Traffic Impact Studies

TRAFFIC IMPACT STUDY

Haven School

Traffic Impact Study

Figure 19 – Intersection Sight Distance

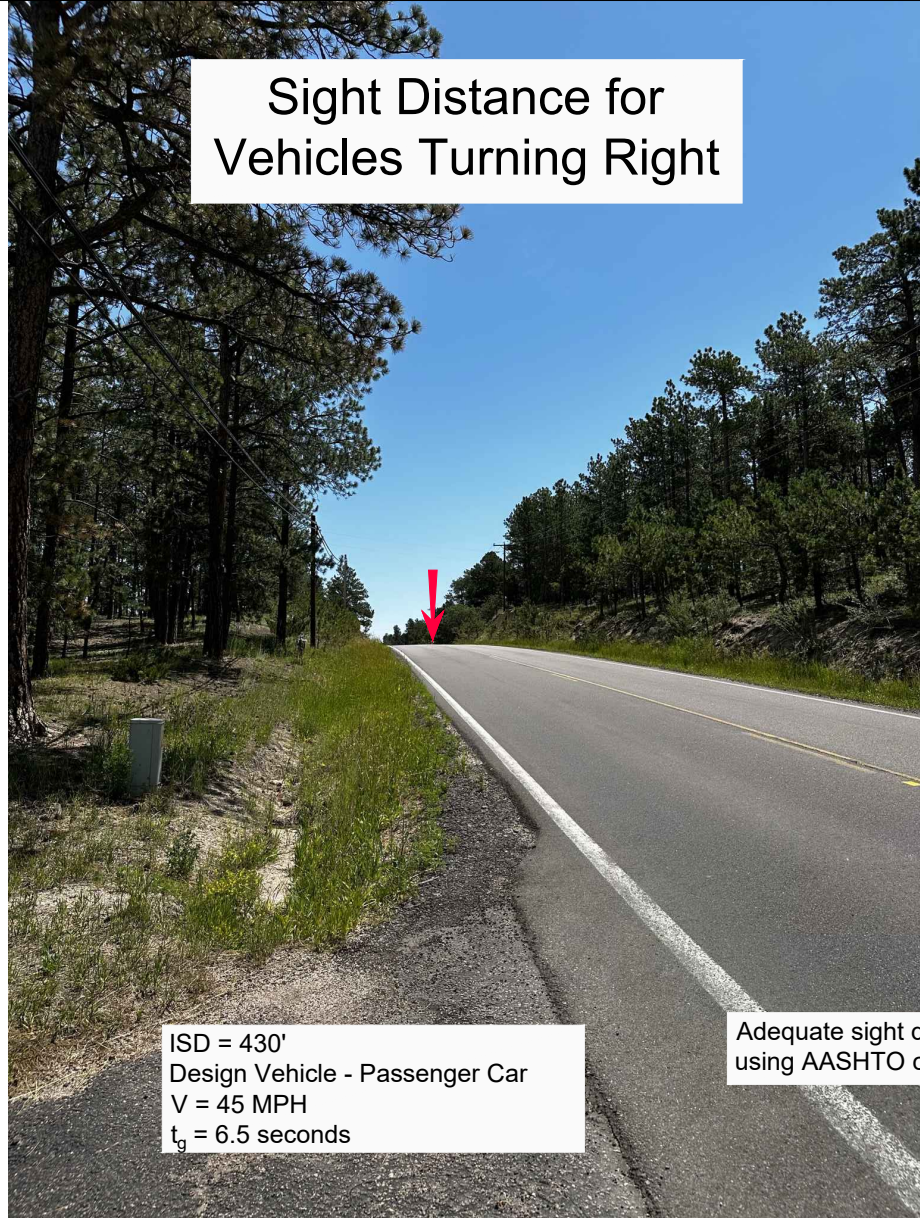
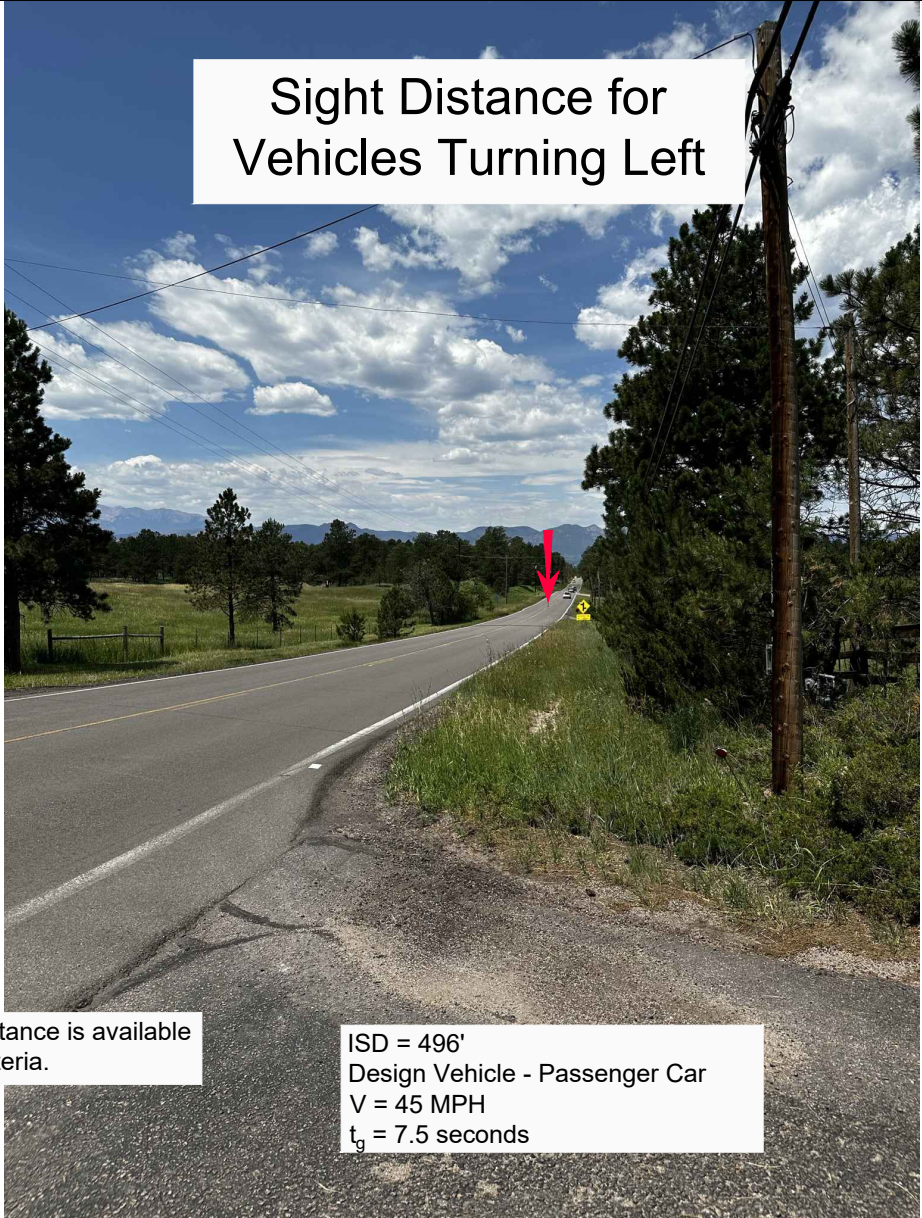
Please state in the text what the ECM sight distance criteria are and state whether they are met.
